Application no: H06/1220/99

Applicant: S E King Building Contractor
192 Bridge Farm
New Road
Sutton Bridge
Spalding Lincs PE12 9QE
Description: Erection of chalet bungalow
and garage

Location: Plot adj. Chapel House
Main Street
Gedney Dyke
Spalding Lincs

ACKNOWLEDGEMENT OF AMENDMENT

99/34 05B

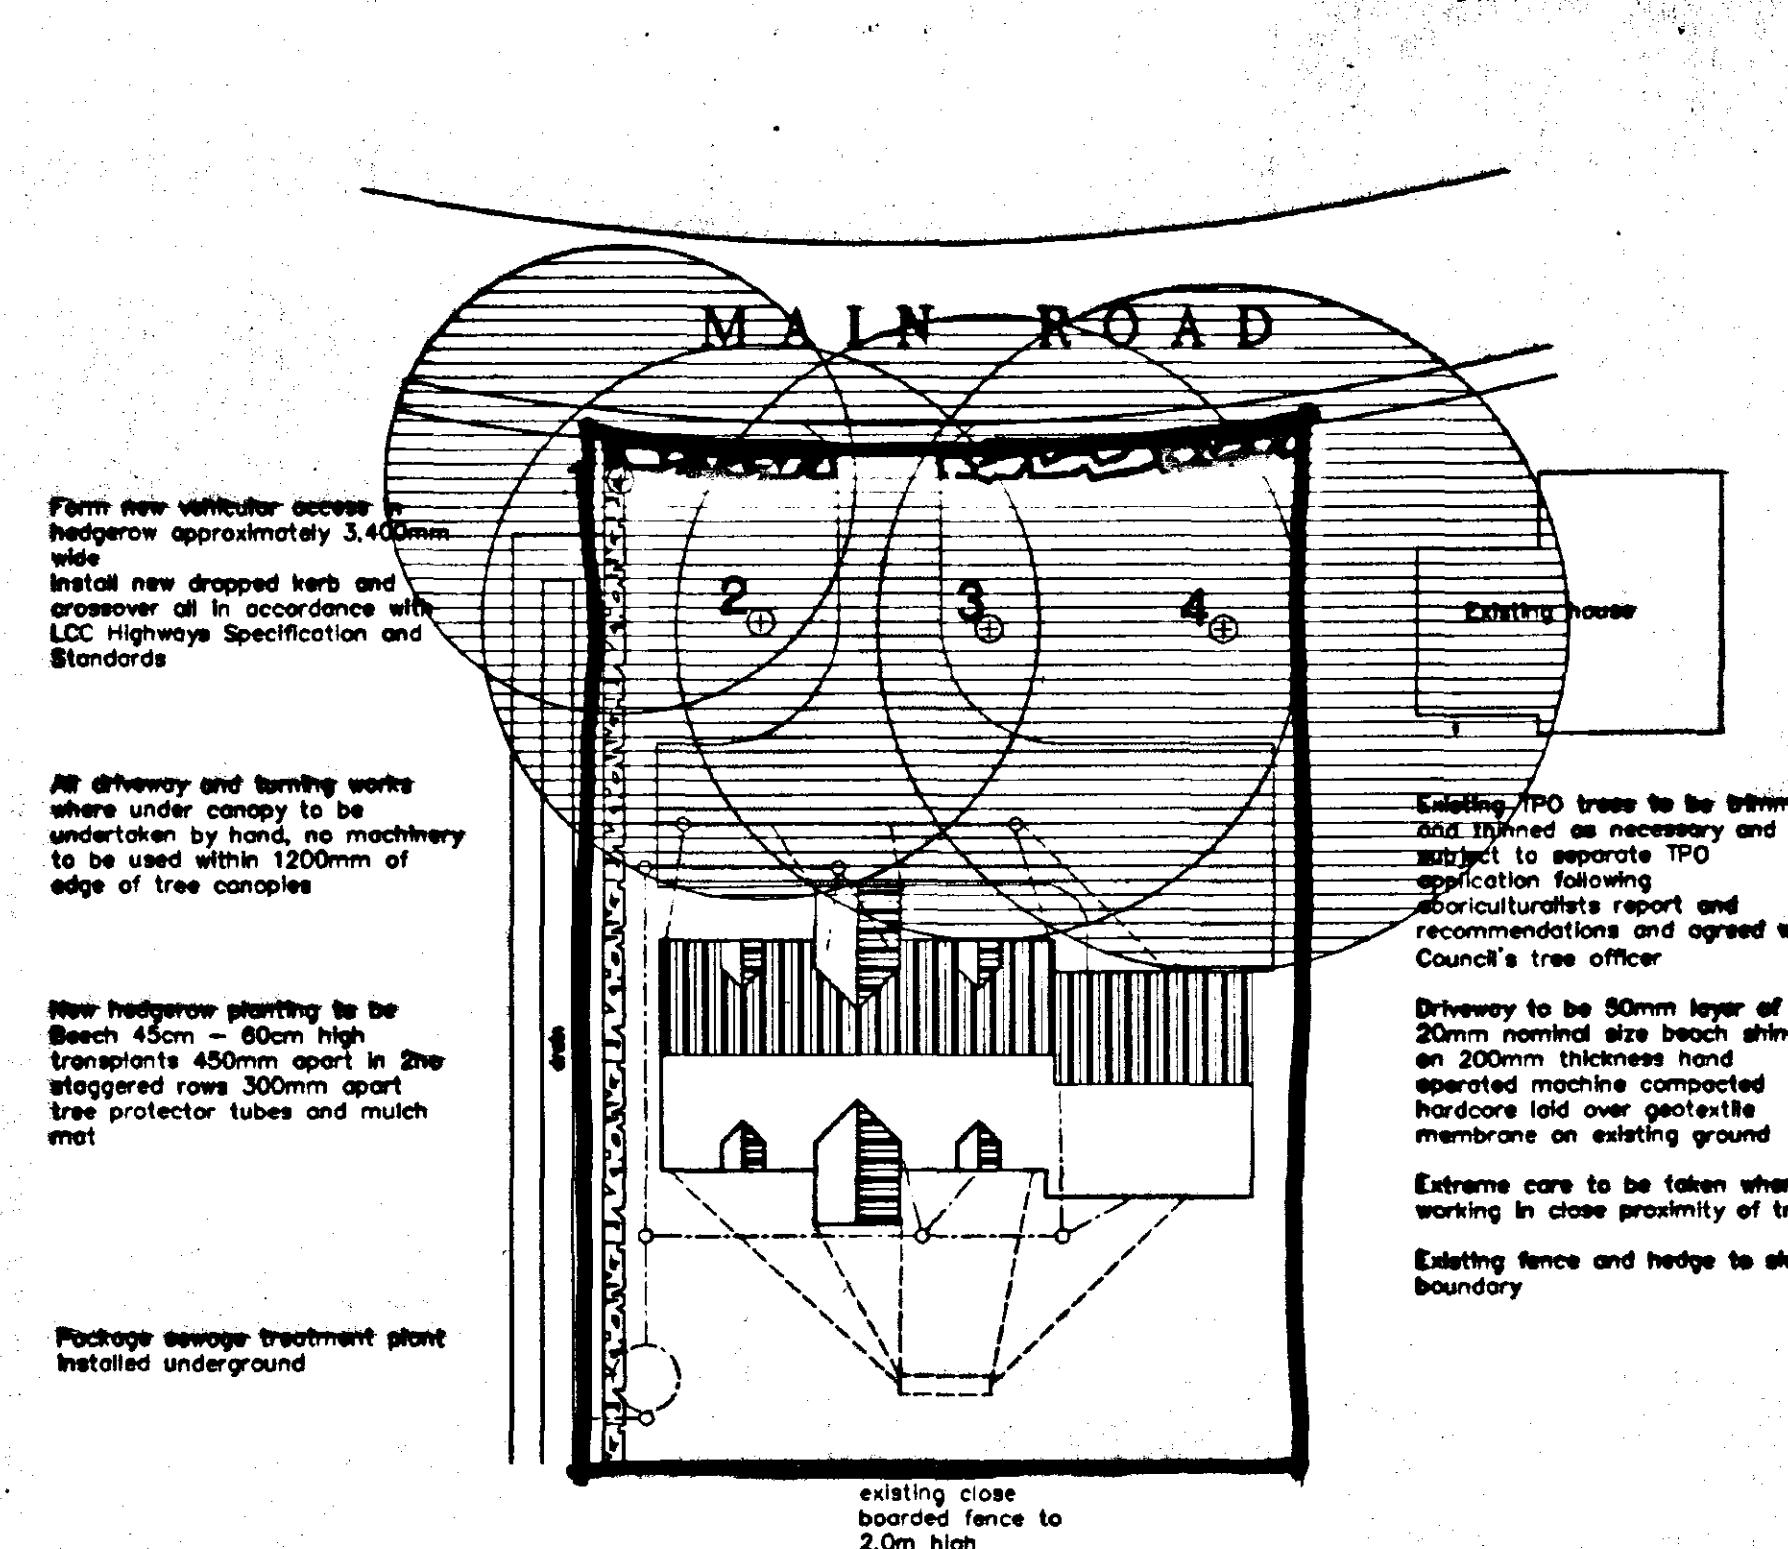
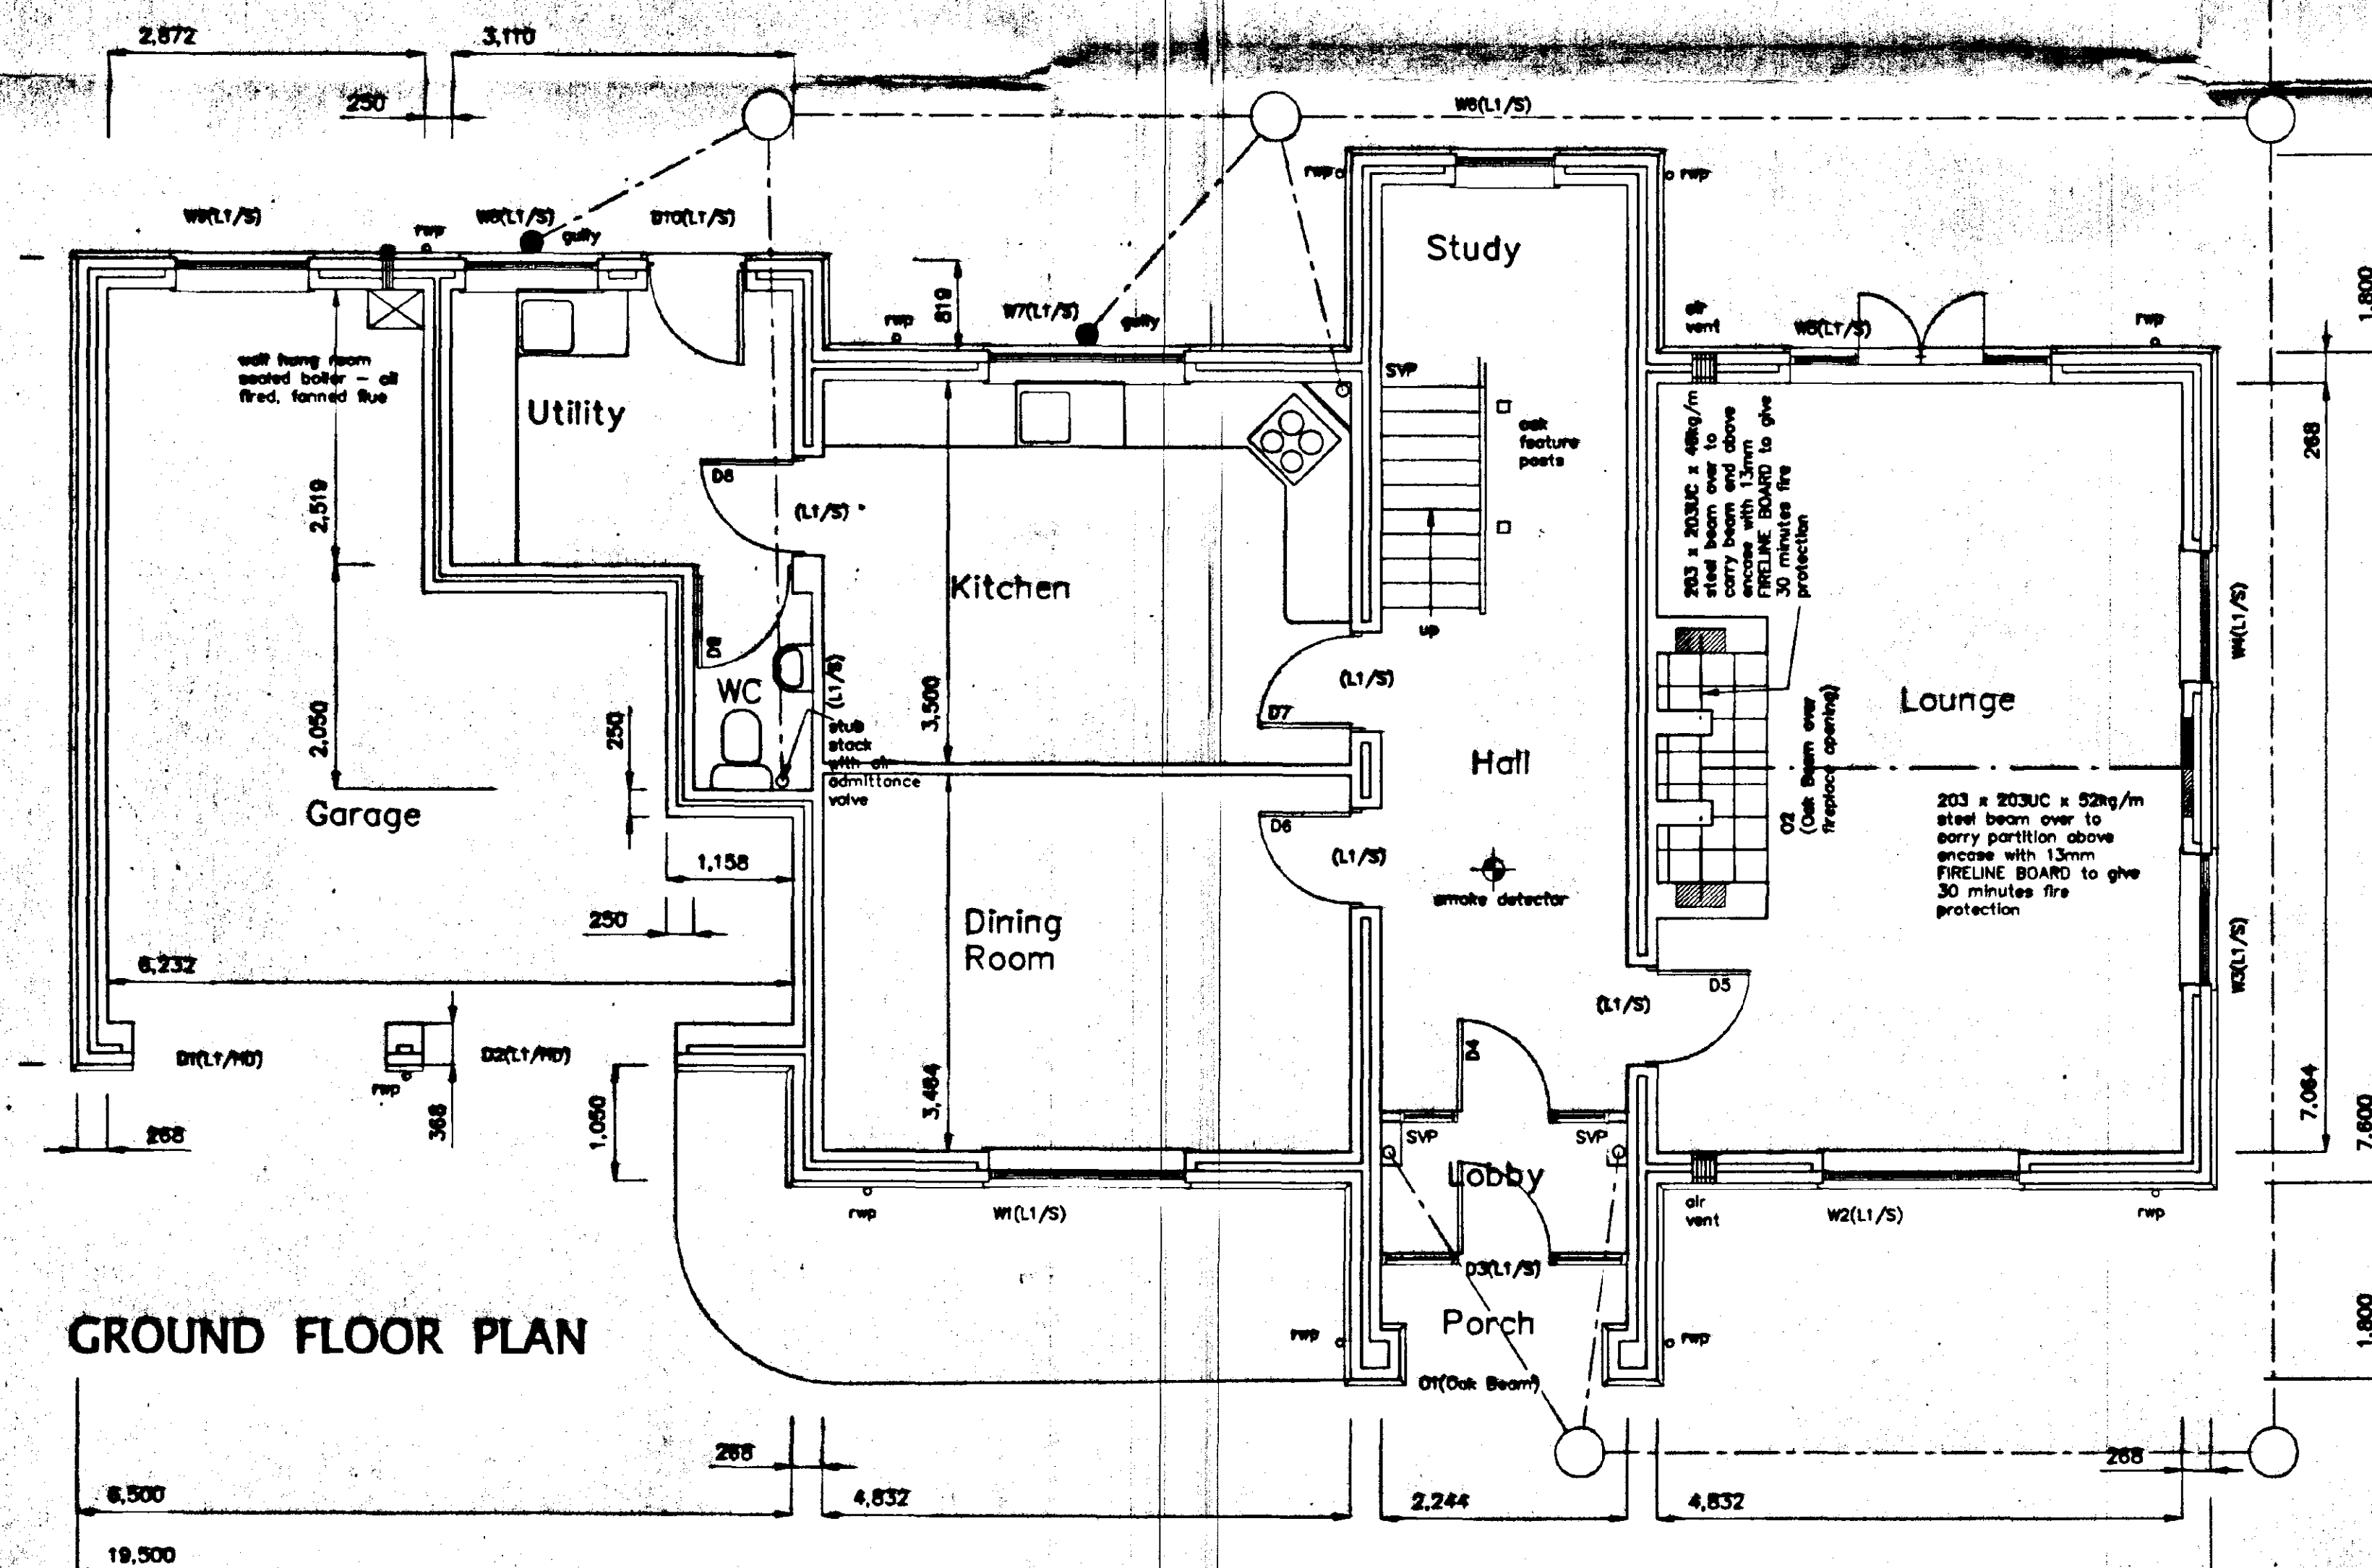
**SPRING OF DWELLING WITH
GARAGE NOW ATTACHED TO
EDGE OF TREE CANOPY SPREAD
ACCESS CENTRALISED
CENTRE TREES TO BE REMOVED.**

Amendment: Dwelling re-sited, garage attached, access re-positioned and
alternative tree to be removed.
